I object to the WestConnex M4-M5 Link proposals as contained in the EIS application # SSI 7485, for the reasons set out below.

Application Number: SSI 7485

Application Name: WestConnex M4-M5  
Link

**Figure 7-8** Indicative Darley Road civil and tunnel site (C4) layout

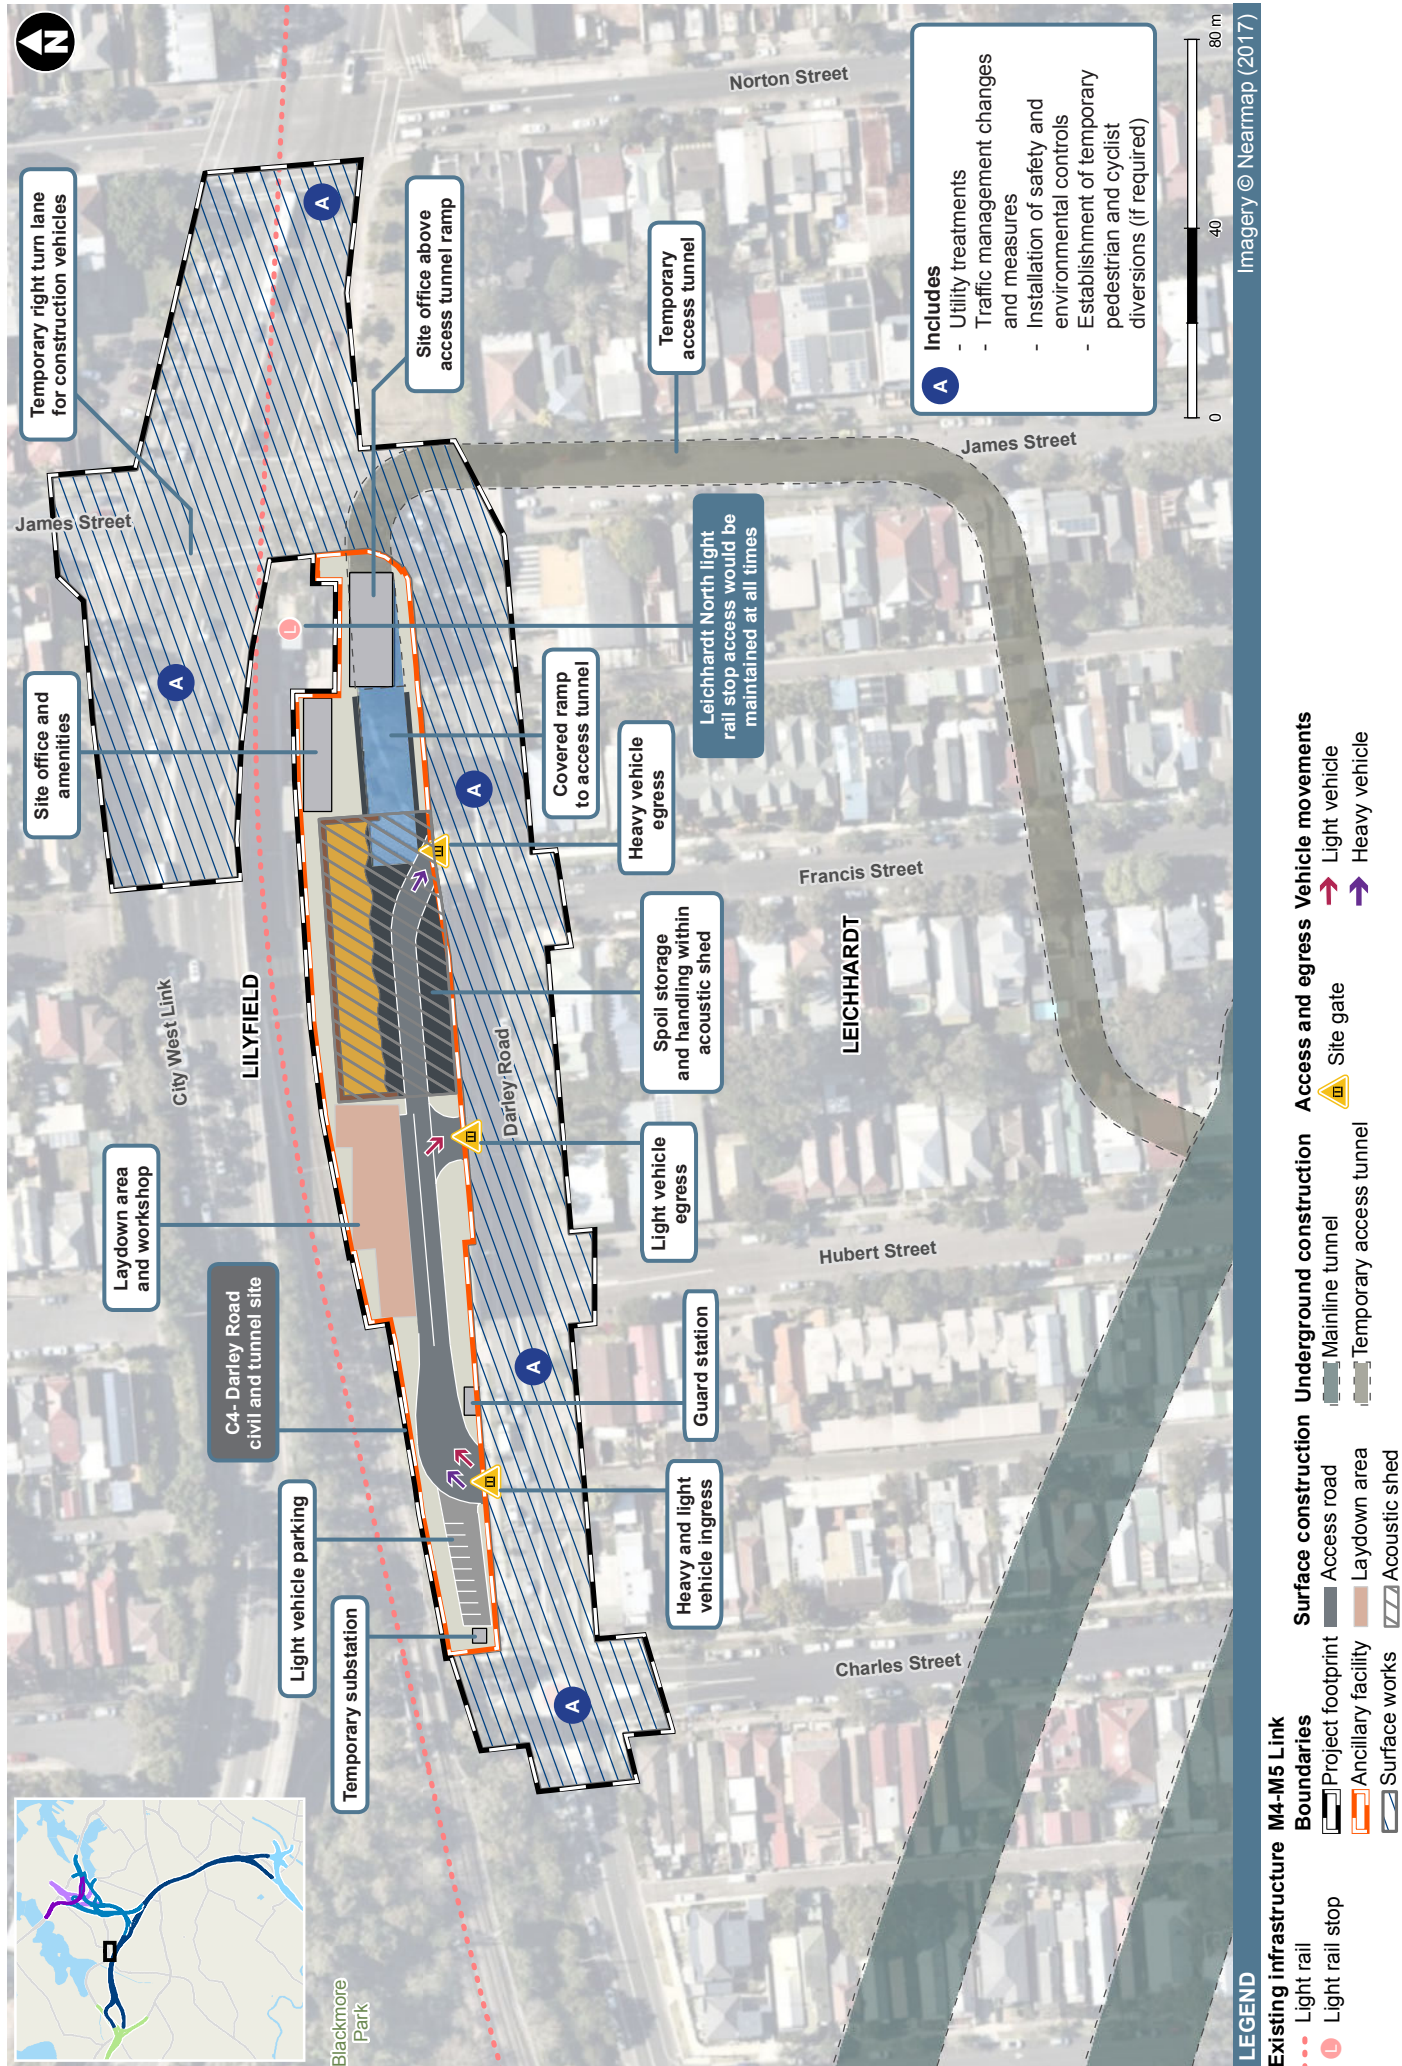
- We object to the selection of the Darley Road site on the basis that it provides for daily movements of 170 heavy and light vehicles accessing Darley Road. This creates an unacceptable risk to the safety of pedestrians accessing the North Leichhardt light rail stop as well as bicycle users accessing the bicycle route on Darley Road and entering Canal road to join the dedicated bike paths on the bay run. Many school children cross at this point to walk to Orange Grove and Leichhardt Secondary College. The EIS states that an alternative truck movement is proposed which involves use of the City West Link with no trucks to access Darley Road. The selection of Darley Road should not be approved if it involves any truck movements on Darley Road, which is what it currently provides.

- Access routes – Leichhardt.** The EIS states that all construction vehicles will enter and leave via Darley Road. Although near the City West Link, Darley Rd abuts a large number of small, local streets and homes and streets near Darley Road will be impacted by a heavy vehicle movement every 3-4 minutes. This is an unacceptable impact. No heavy or light vehicle movements should be permitted on Darley Road whatsoever and an alternative route which does not involve Darley Road is the only route that should be approved.
